WST12/00103/04

**SSD-5355: Lot 34 DP 751328;  
Barrier Highway, Nyngan; Nyngan Solar Plant**

Thank you for your letter dated 11 March 2013 referring the Environmental Assessment (EA) for the proposed Nyngan Solar Plant to Roads and Maritime Services (RMS).

APPENDIX E INDICATIVE INFRASTRUCTURE LAYOUT

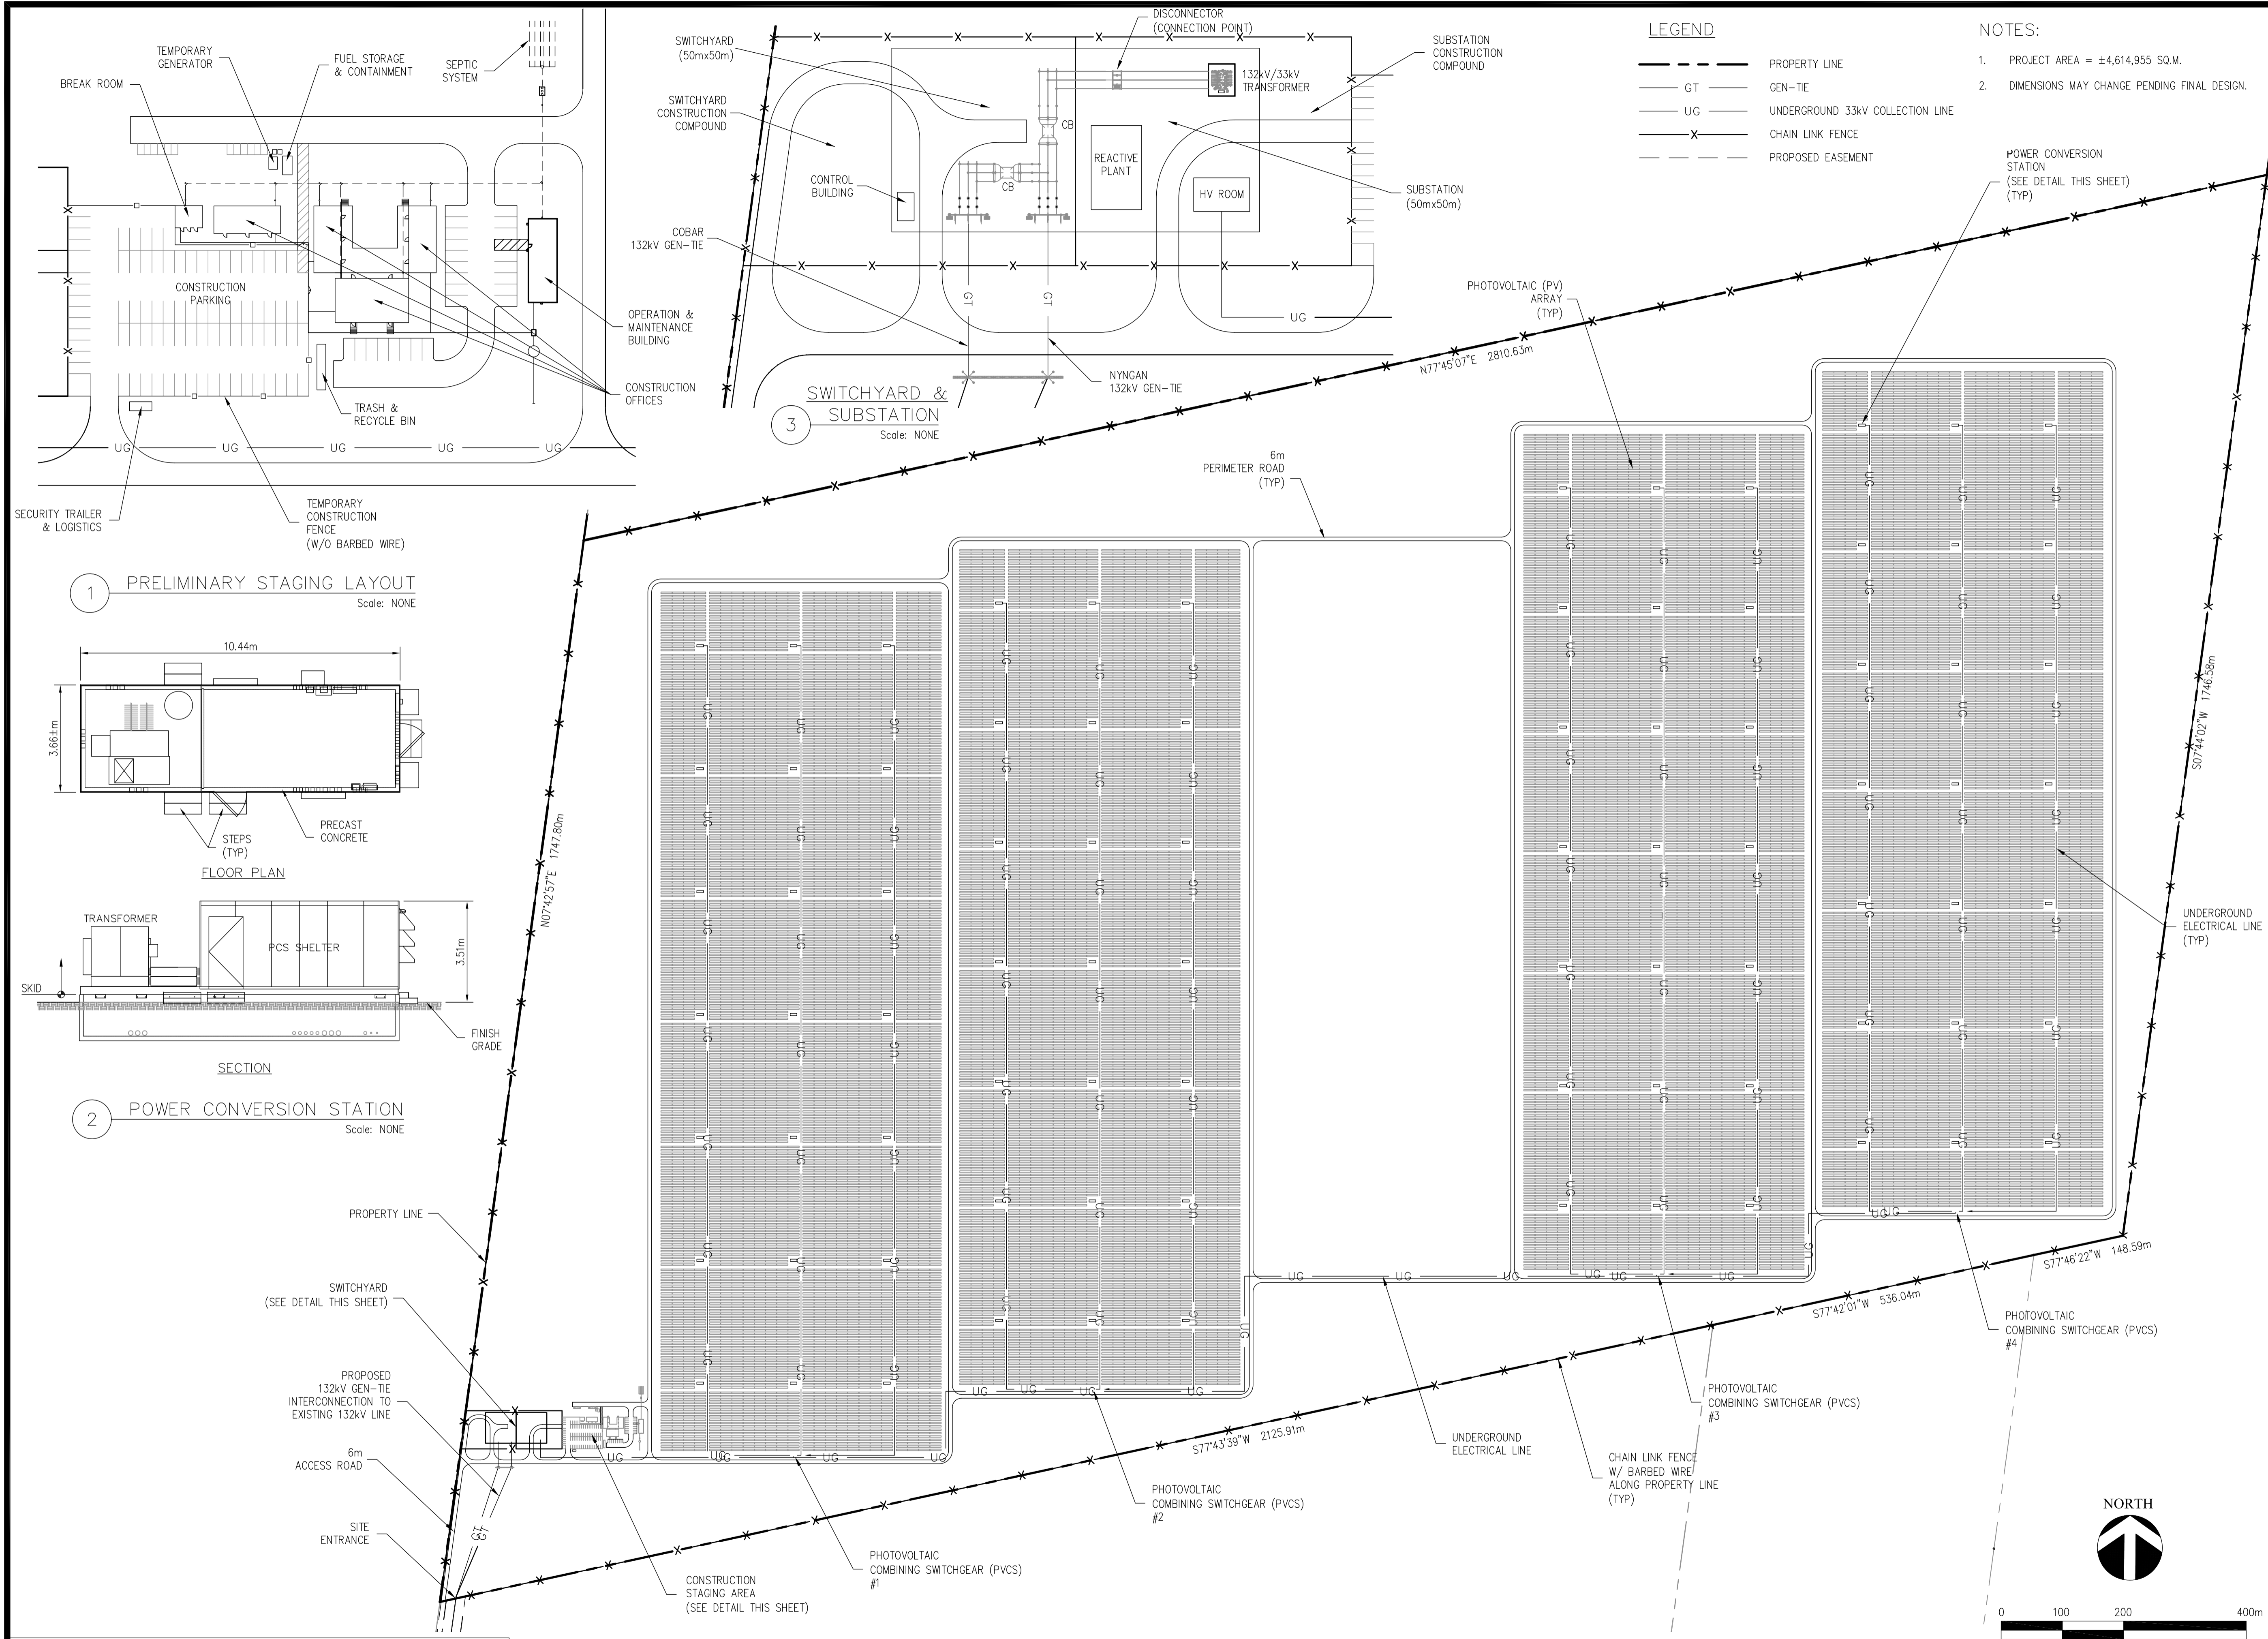
- The access to the subject land from the Barrier Highway shall be upgraded to provide for the safe movement of traffic entering and exiting the site. In this regard, a Traffic Management Plan and Haulage Plan shall be prepared in consultation with RMS to outline measures to manage traffic related issues associated with the delivery and construction of the solar plant, ancillary structures, transportation of excavated materials, machinery and personnel involved in the construction, operation and decommissioning stages of the project. The plans shall detail the potential impacts associated with the development, the measures to be implemented and the procedures to monitor and ensure compliance. This plan shall address, but not necessarily be limited to:

- (e) Details of intersection improvement works in accordance with *Austroads Guide to Road Design 2010* and RMS Supplements;
- (f) A full and independent risk analysis and inspection of the proposed transport route(s) with procedures for reporting and remediating any damages caused by over size/over mass traffic;

- To provide suitable storage capacity for the largest class of vehicle accessing the proposed lots, any gate, grid or similar structure installed in the access should be setback appropriately (20m for single articulated) from the edge of the road on the Barrier Highway;
